**Subject:** Submission on Ballinlee Green Energy case no 323780

**Re: ABP case reference : PC91.320745**

**Applicant: Ballinaslee Green Energy limited**

Located within the townlands of Ballincurra, Ballinlee South, Ballingayroure, Ballinbea, Knockuregare, Ballinlee North & Camas South approximately 18km southwest of Limerick City & 4km west of Bruff, Co Limerick

Figure 2-8: Wind Farm Site Layout

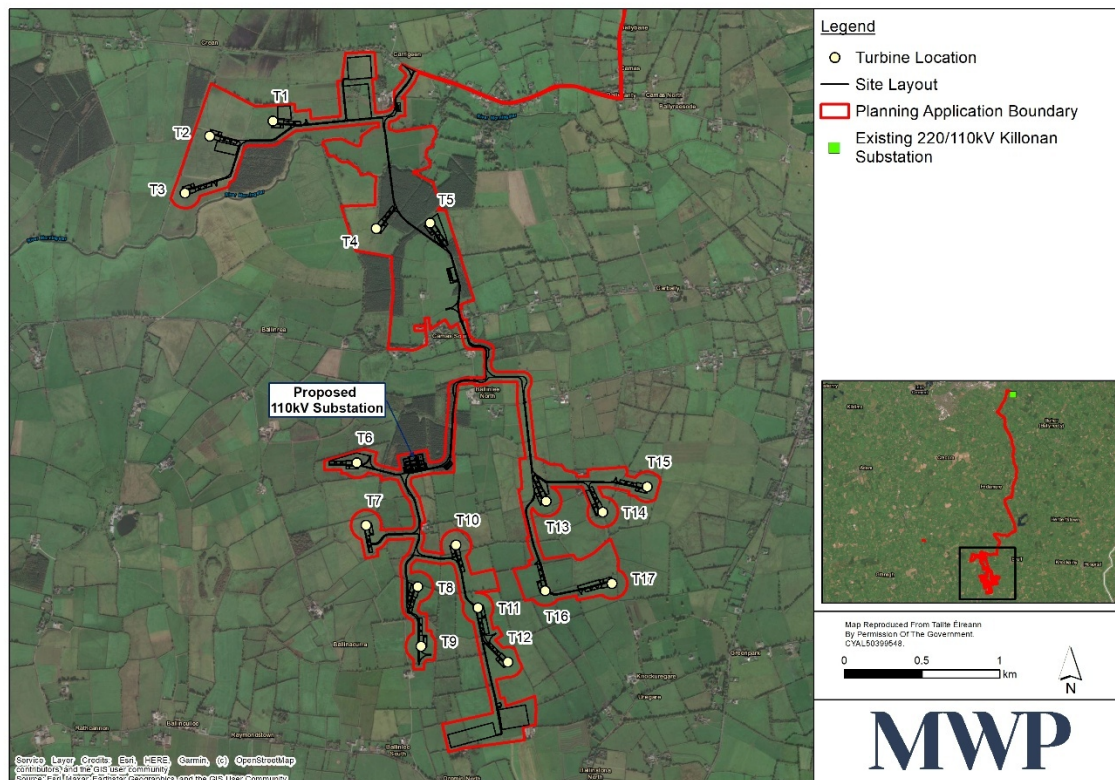
In ABP case reference **320745** to which this observation refers, the applicant has, as one can see in Map 1, (next page) ignored the turbine separation distances from adjacent turbines, that are recommended in the WEDG2006 guidelines.

It should be noted that the prevailing winds, those requiring 7 rotor diameter separation distance between turbines are not only from the southwest direction. Map 1 shows that in reality there are significant winds of significant duration from 150 South-southeast to 350 North-northwest.

Therefore the positioning of all turbines are in prevailing wind direction’s relative to each other. This then says that all turbines should be a distance of 7 rotor diameters apart per the WEDG2006 guidelines and 5 rotor diameters per the Manufacturers guidelines.

Map 1 shows that the spacings between T1 to T4 and T4 to T6 are the only pairings that have the recommended spacings per WEDG2006 guidelines.

All other spacings are sub-standard and will, in my learned opinion, cause noise nuisance similar to the Meenacloughspar (Ballyduff) and Gibbett hill windfarm cases that have been established in the courts.

It is my opinion that the developers will not get a valid warranty for the eventual turbine, after their tender process, for a spacing less than 5 rotor diameters in the prevailing wind direction and 3 rotor diameters in other directions. The layout on Map 1 shows a significant lack of spacing, using the manufacturer’s recommendations and a serious lack of spacing relative to the WEDG2006 guidelines.
